Planning Application Ref: AW/111/19/T

Location: 63 Barrack Lane, Bognor Regis, PO21 4DE

Description of works: Prune limb on eastern aspect by maximum 3m to 1 No. horse chestnut tree

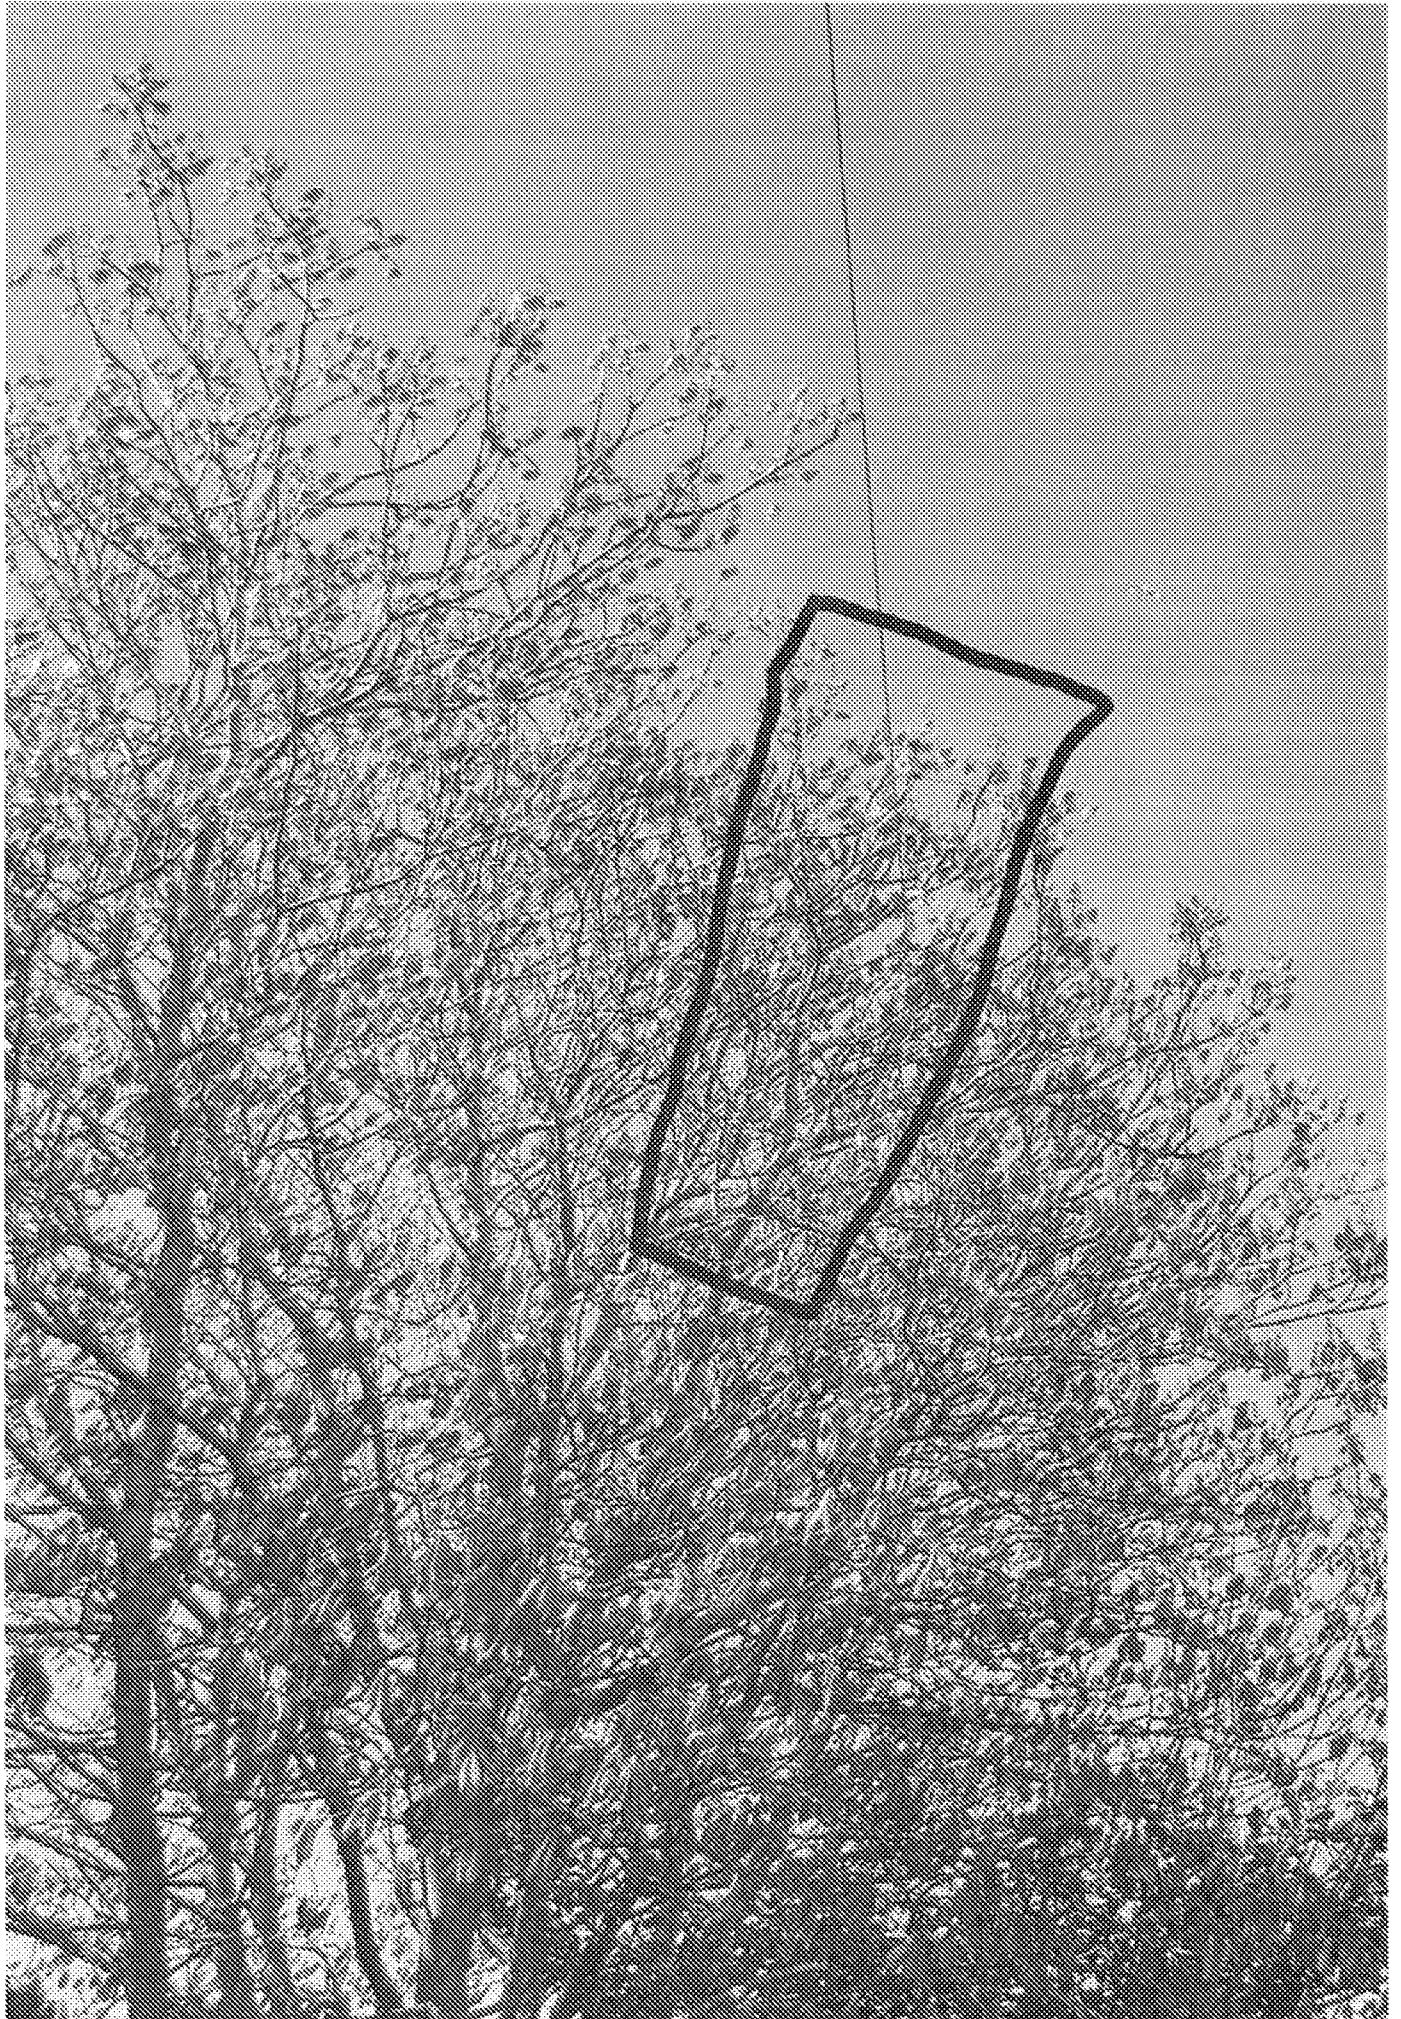
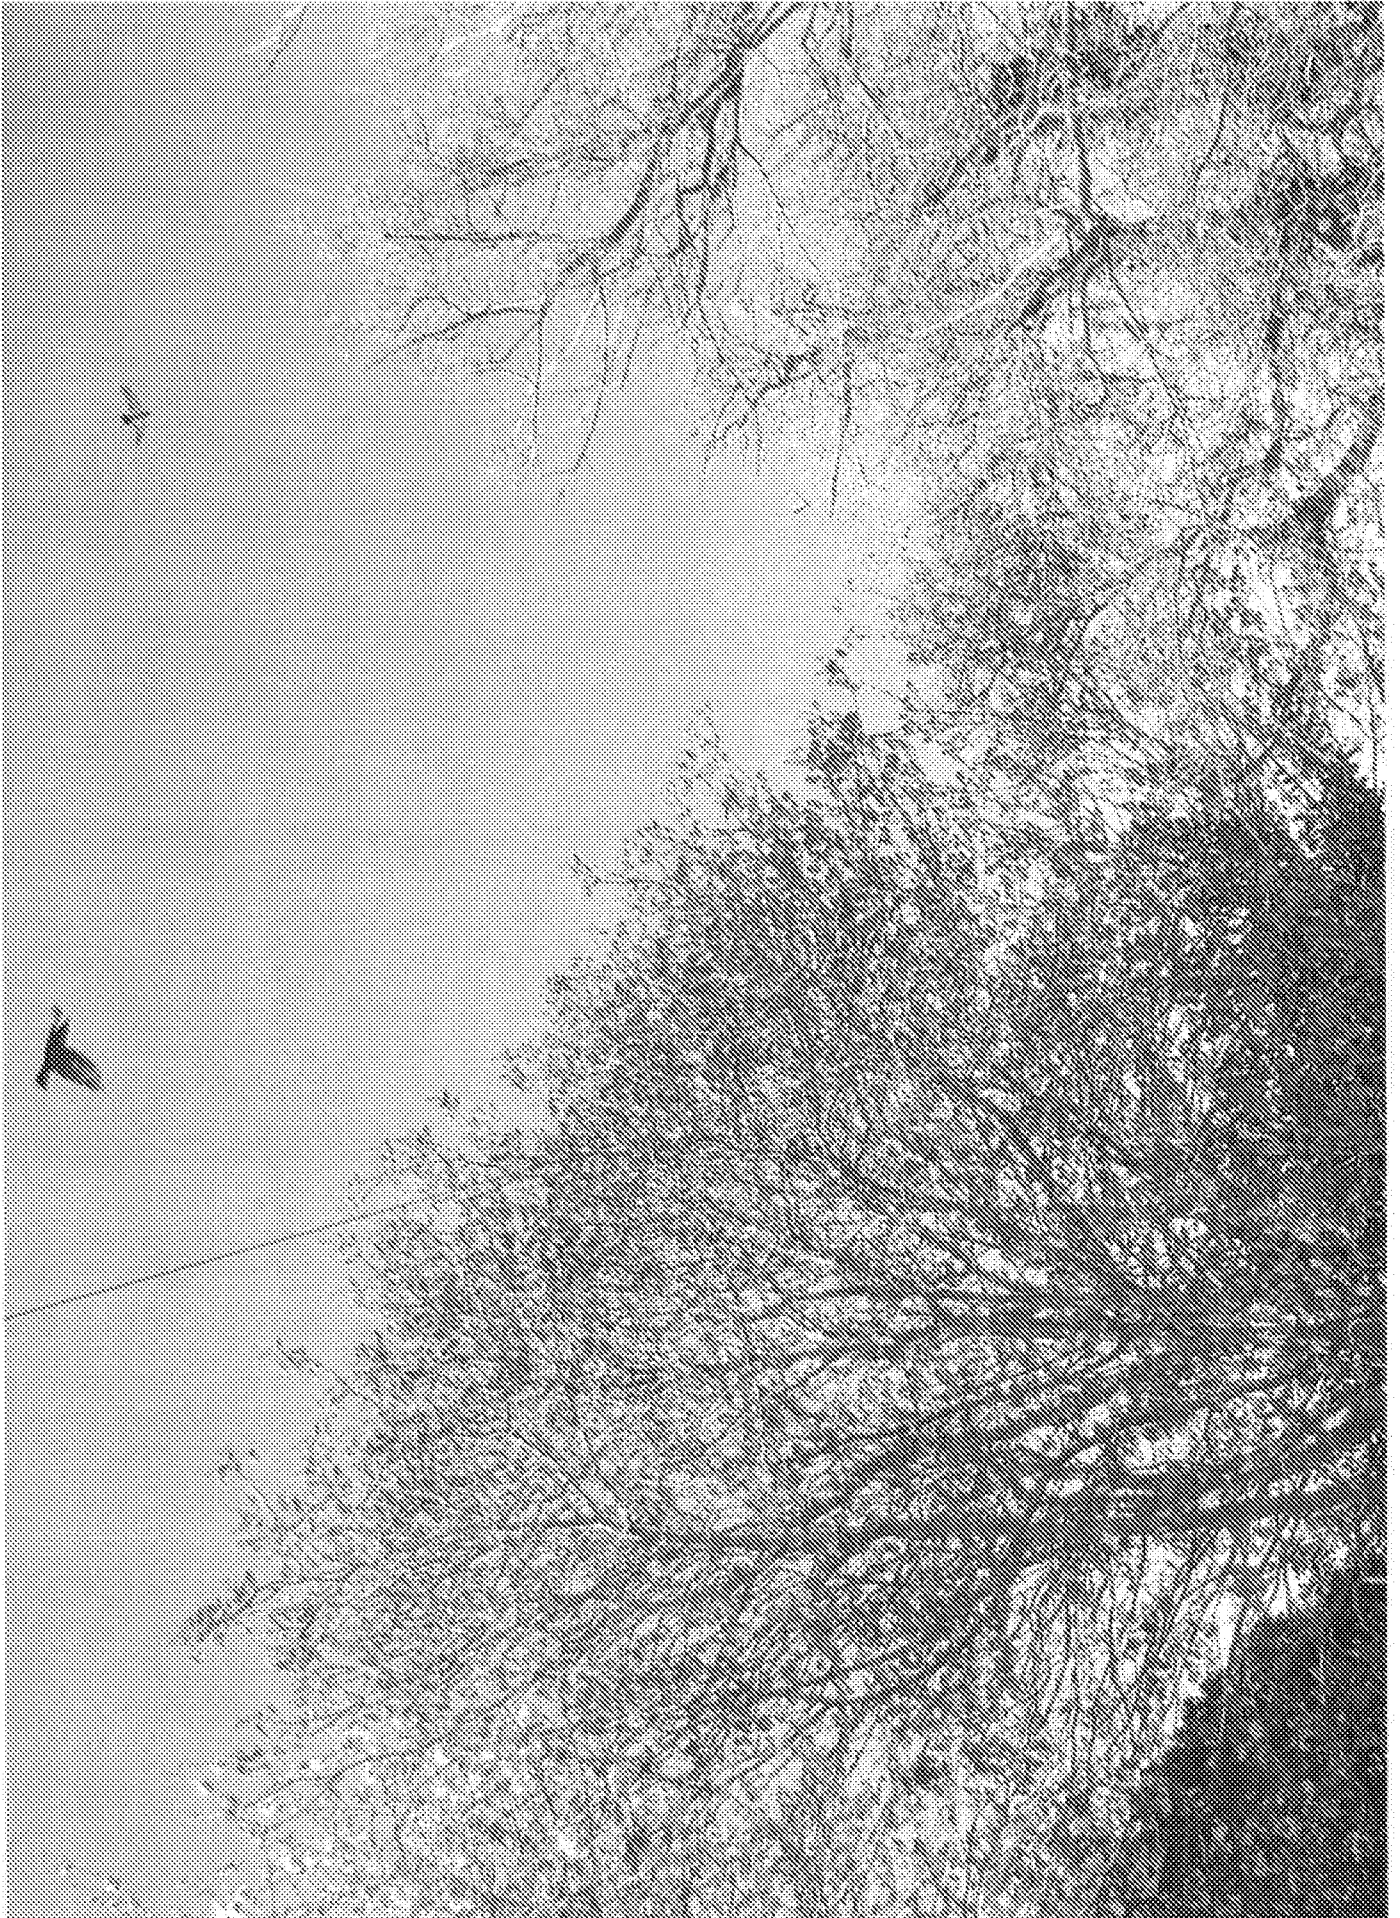
- This tree appears to be outwardly healthy and stable with a relatively unmodified and attractive crown profile.
- It grows at the front of the property and is prominent roadside, with potential long-term landscape value. As such, it has public amenity value.
- The applicant has expressed concern about the potential for abrasion to the overhead cable from branches directly touching, especially during episodes of high wind speed.

- This tree has potential to become a high profile specimen tree of significant public and visual amenity and so must be carefully pruned so as to maintain integrity of utility apparatus and respect natural tree form.
- Some careful and selective pruning is necessary to ensure free passage of the cable through the crown and so the application in principle is justified on arboricultural grounds; although I find the work description problematic as it could result in permanent spoiling of that aspect of the tree and the formation of unnecessarily large wounds.

- As it stands, I recommend **REFUSAL** for this application.

- I would like to see the applicant submit a revised specification for lesser work such as described below, which would seem to address their concerns whilst preventing a diminution of the tree's landscape and public amenity value:
 - Reduce/remove small branches (<75mm diameter) as necessary to achieve no more than 0.5 metres clearance from around overhead (BT) cable routed through the crown.

- Where whole branches are to be removed and final cuts made close to the trunk or branch union they are to be made as shown in Figure 2 of BS3998:2010
- Where branches are to be shortened back the final cuts are to be made at the correct angle shown in BS3998:2010 and adjacent to a live bud or lateral.
